# Access Review

Meriden School for Girls

SSDA Projects

Report Issue 4 [FINAL]

Drawing Title
**FLOOR PLAN - LEVEL -2
(BASEMENT)**

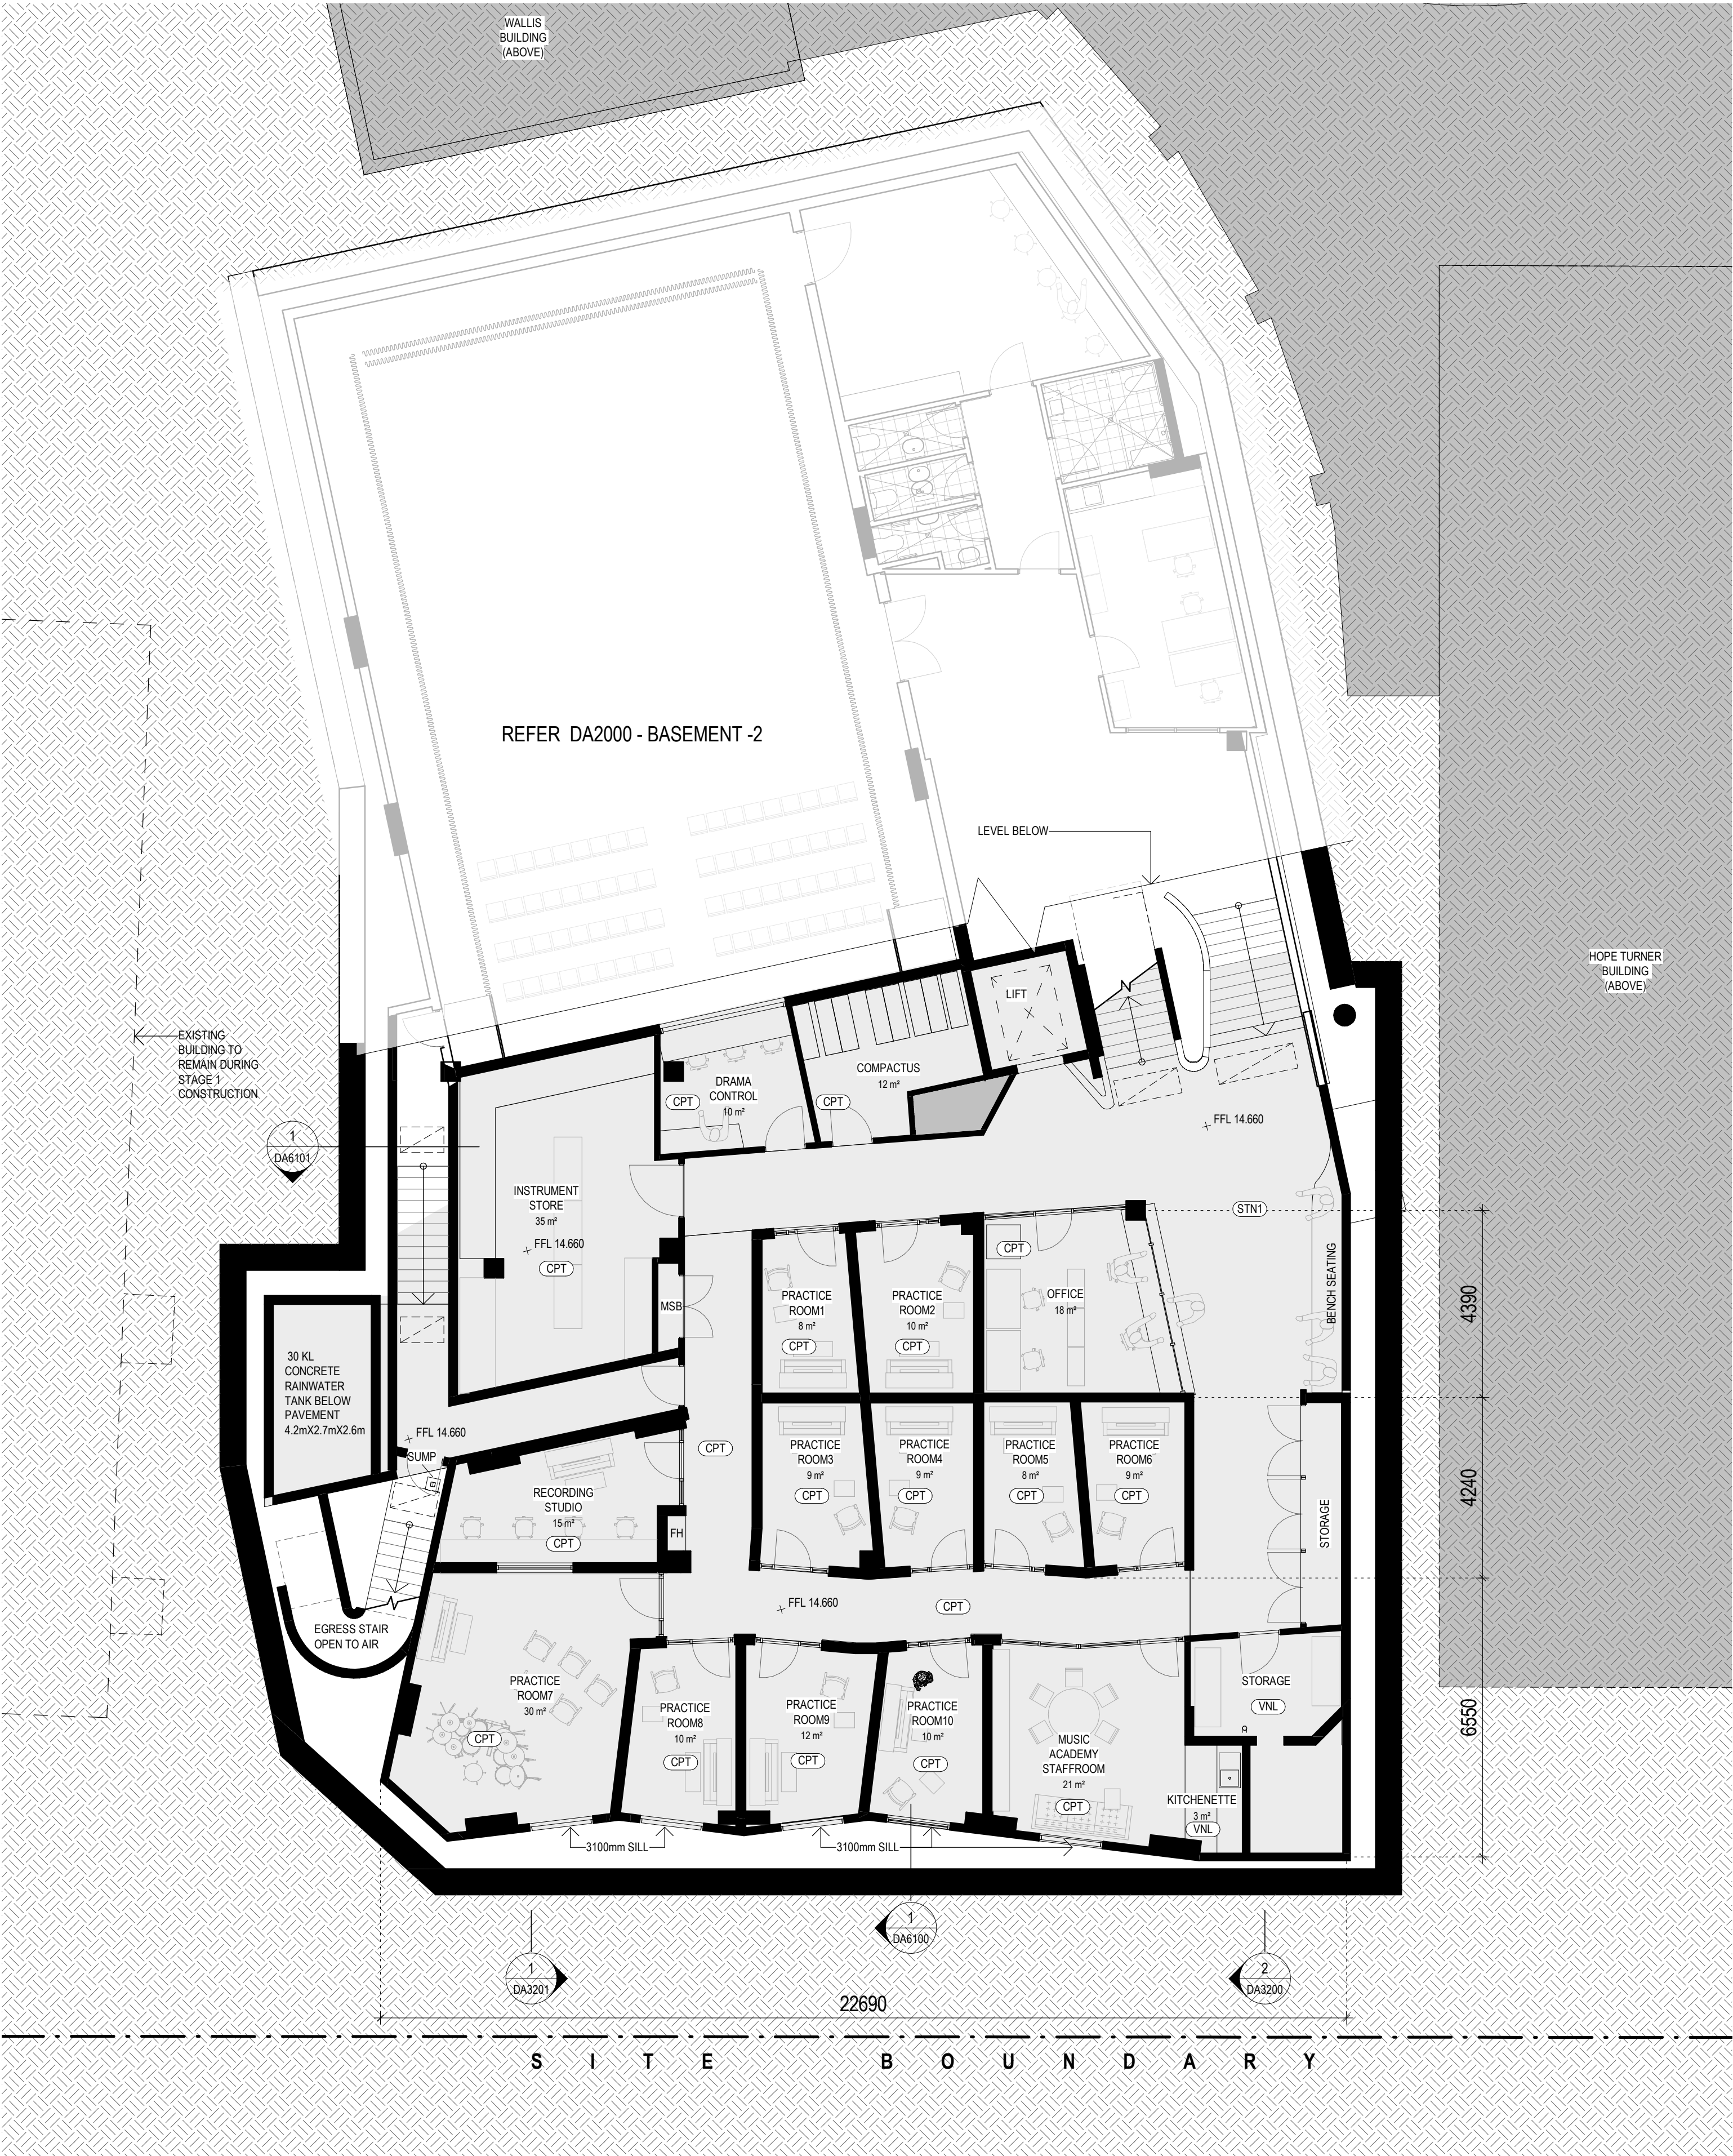
Tgsi are not currently indicated at stairs 01, 02, 03 (level 1 basement), 04 (level 01 basement), stair 05, stair 06 (level 0 ground), amphitheatre stairs.

To meet the BCA (2016) part D3.3 (a) stairways, (except for stairways in exempted areas and fire isolated stairs) are required to comply with AS1428.1 clause 11 and BCA D3 to include handrails, highlighting on step nosing and tactile ground surface indicators.

To meet the requirements of the BCA (2016) part D3.8 tactile ground surface indicators (tgsi) complying with AS1428.4.1 (2009) are required to be provided at stairways.
